**Kembla Grange Resource Recovery Facility (SSD-5300)
Section 4.55(2) Modification for Loading and Transport 24 Hour Operation (MOD 3)**

ATTACHMENT 1

DPIE Issues - SSD-5300 MOD3

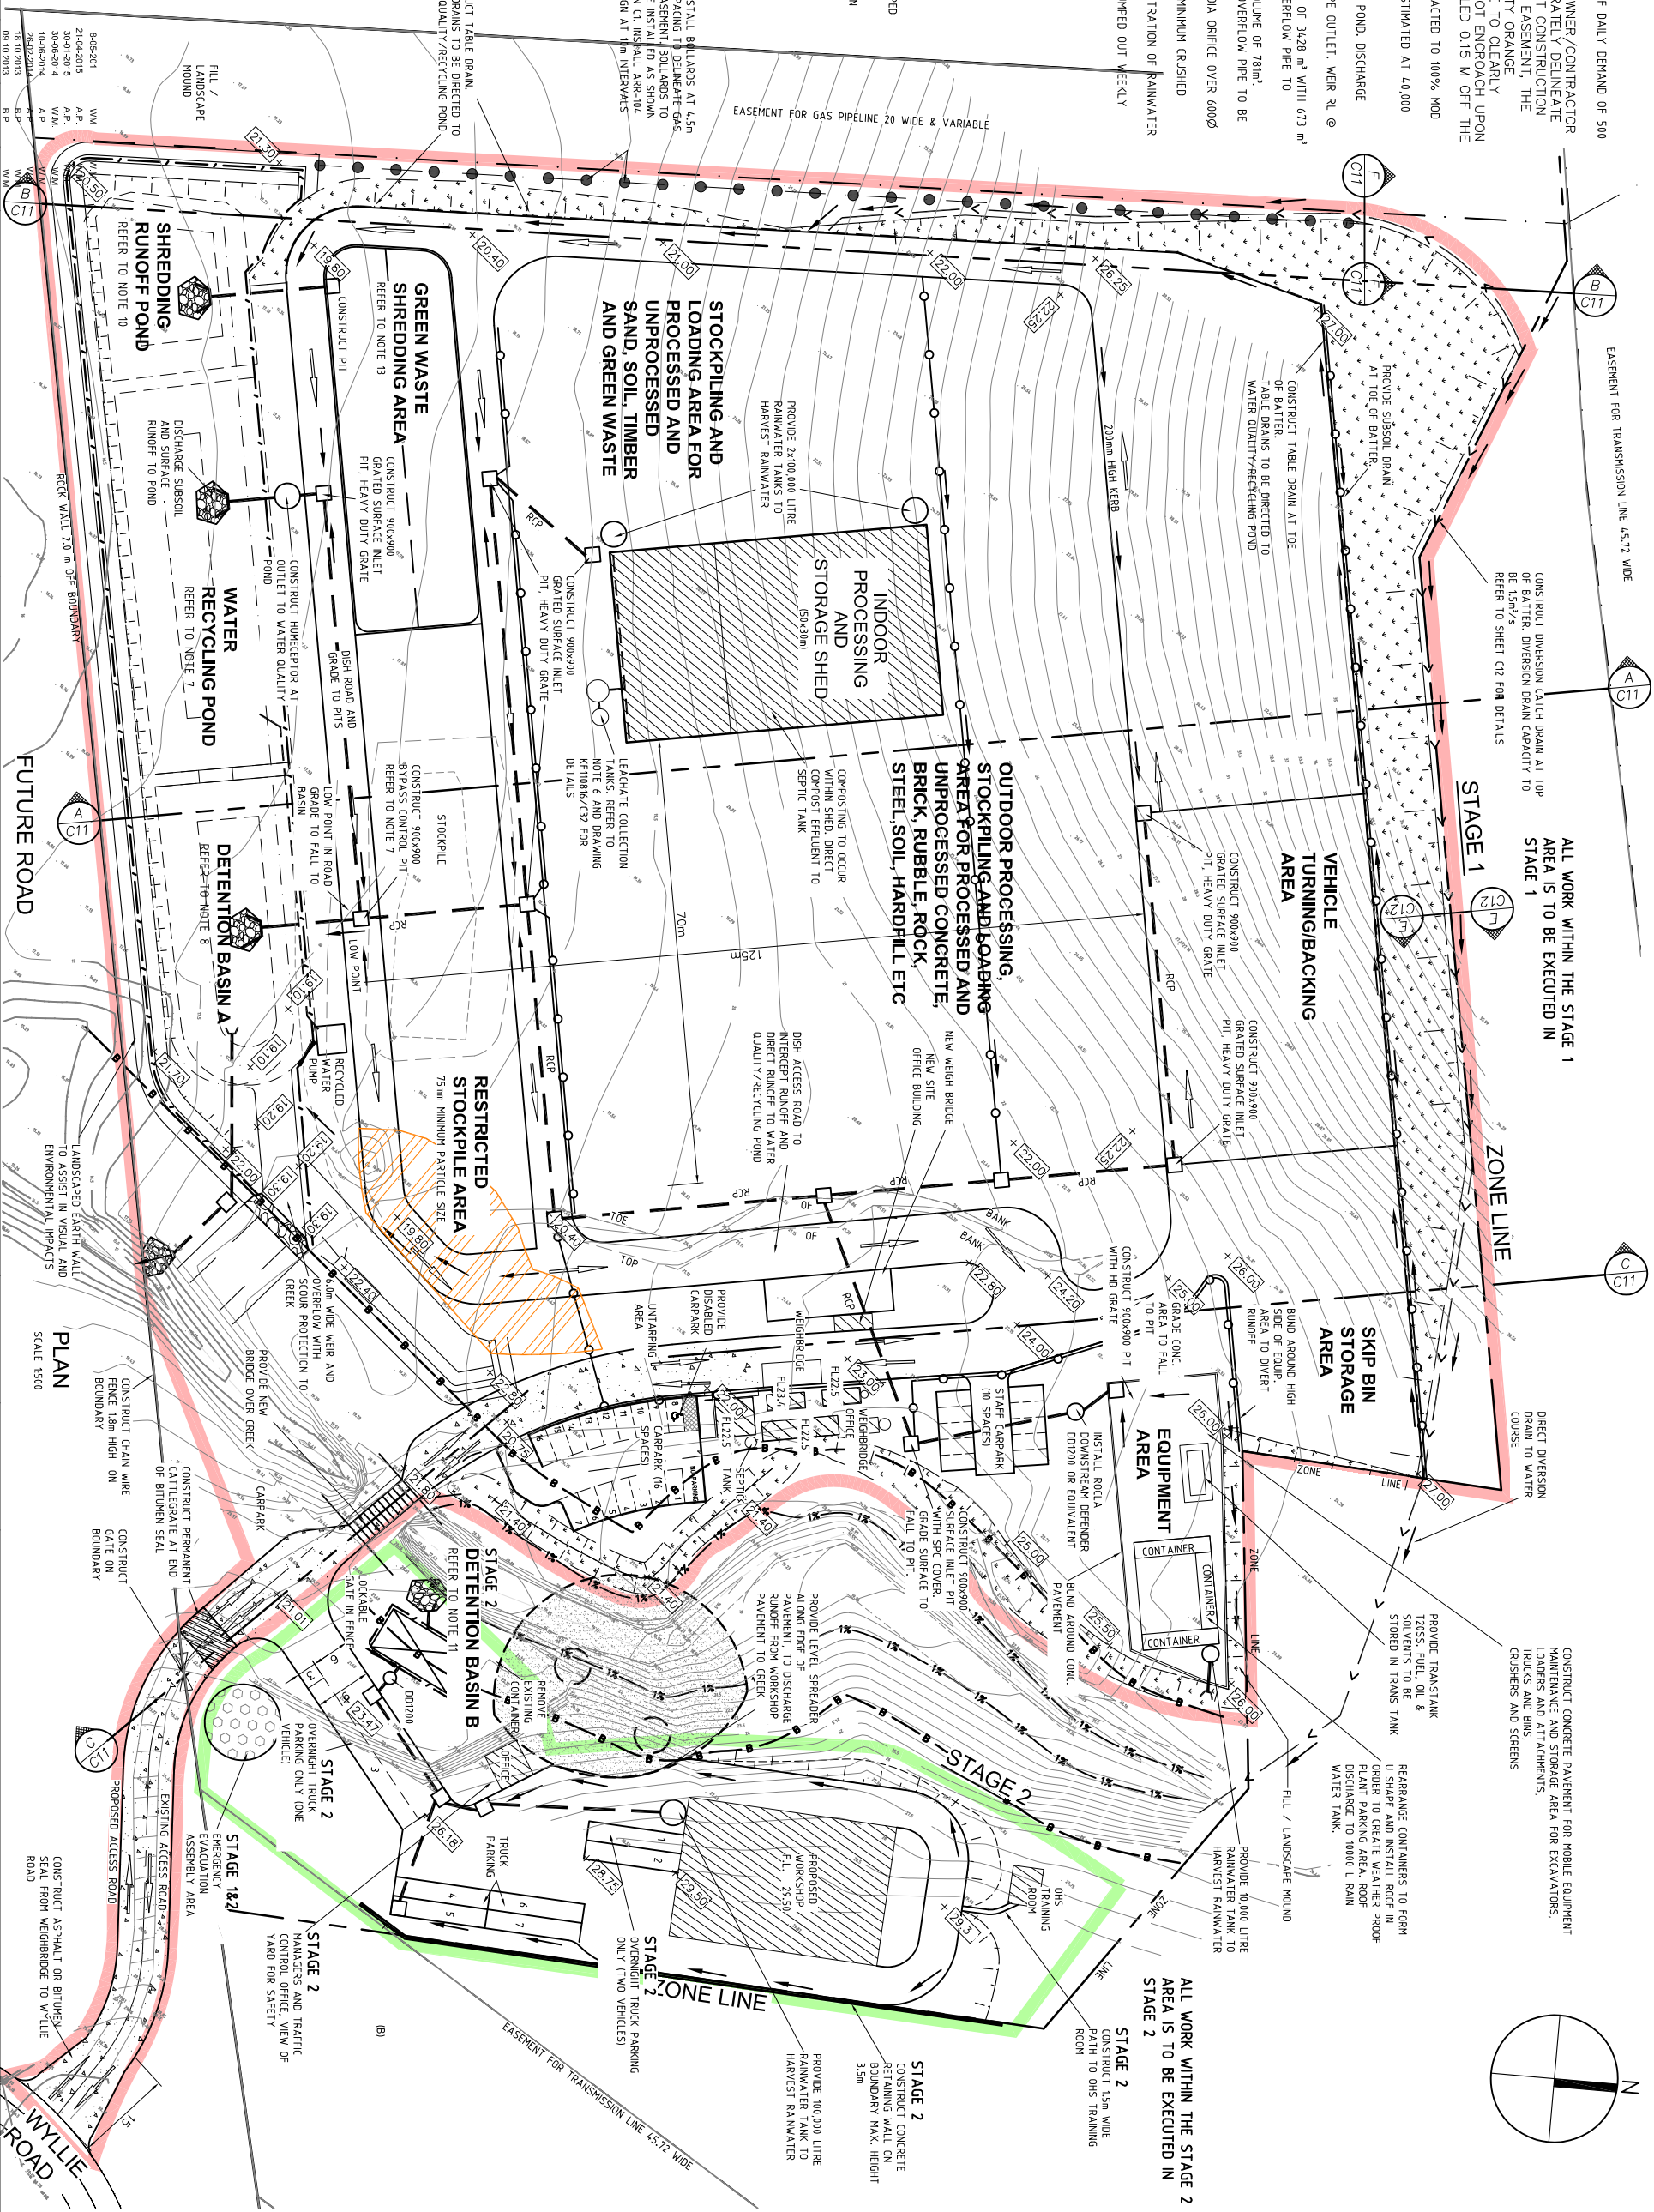
- Table E1.1 and Table 3.1 in the SEE propose 'Operational', and 'Other Operational' activities on a 24-hour basis, however this description does not provide enough detail. For both the 'Operational', and 'Other Operational' categories, clarify the proposed activities, including any plant and equipment used and the proposed time band.
- Clarify operational areas for night-time truck manoeuvring and loading using an appropriate site plan.
